WEST SUSSEX COUNTY COUNCIL CONSULTATION

TO:	Arun District Council FAO: James Cross
FROM:	WSCC - Highways Authority
DATE:	12 February 2020
LOCATION:	Langford Horsemere Green Lane Climping BN17 5QZ
SUBJECT:	CM/64/19/PL Residential development comprising 1x3-bedroom bungalow, 2x3-bedroom houses, 2x2-bedroom houses 4x4-bedroom houses along with access and parking following demolition of existing dwelling - Departure from the Development Plan. An amendment received on 29th Jan 2020.
RECOMMENDATION:	No Objection

Drg No: 190725/SL-01
Rev: K

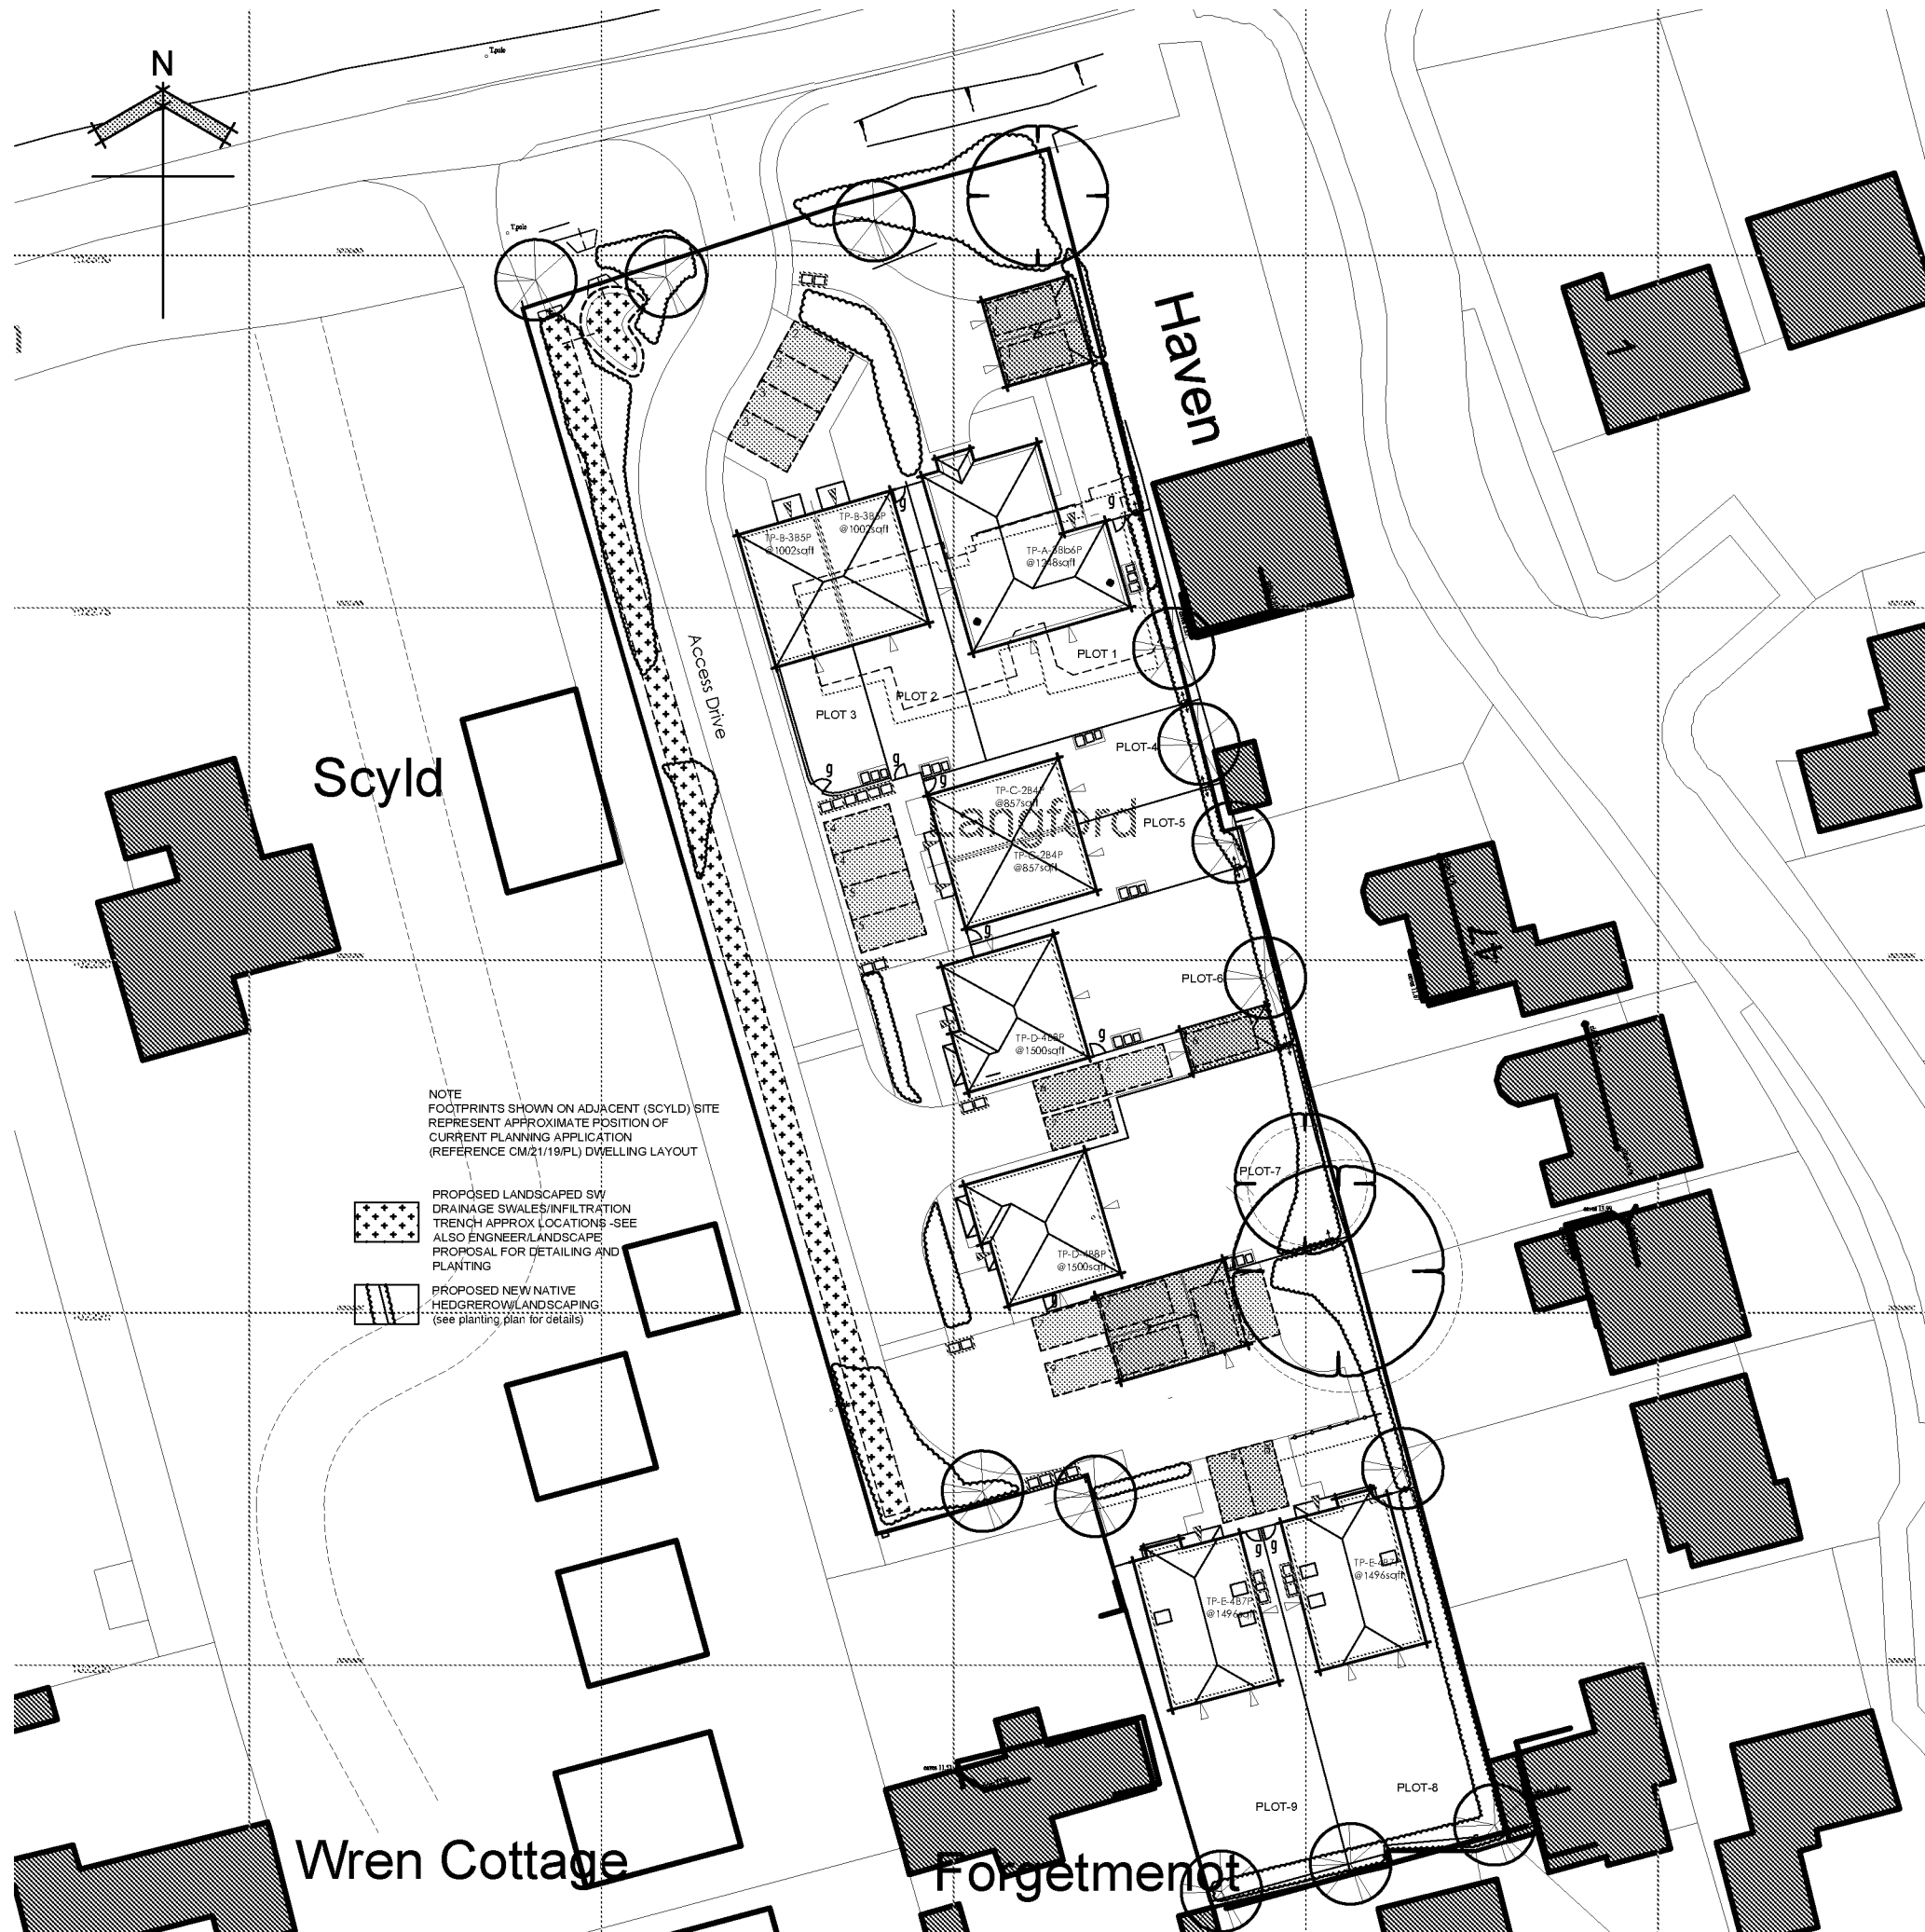
An amended plan has been received detailing the proposed length of footway to extend from the existing footway at Appletree Walk into the site access. The footway and access works would require technical approval from WSCC Implementation team. It is considered that the footway demonstrated will improve pedestrian accessibility to the site from the wider area and could tie in with additional footway that will be provided in the future from a contribution sought under application CM/1/17. It is understood that the Local Planning Authority (LPA) will secure these works through a s106 agreement, though the LHA also consider this could be secured through part of the access works condition.

The amended parking plan shows that two additional visitor parking spaces and an additional allocated space for plot 9 have been provided and indicates electric vehicle charging points within the car ports.
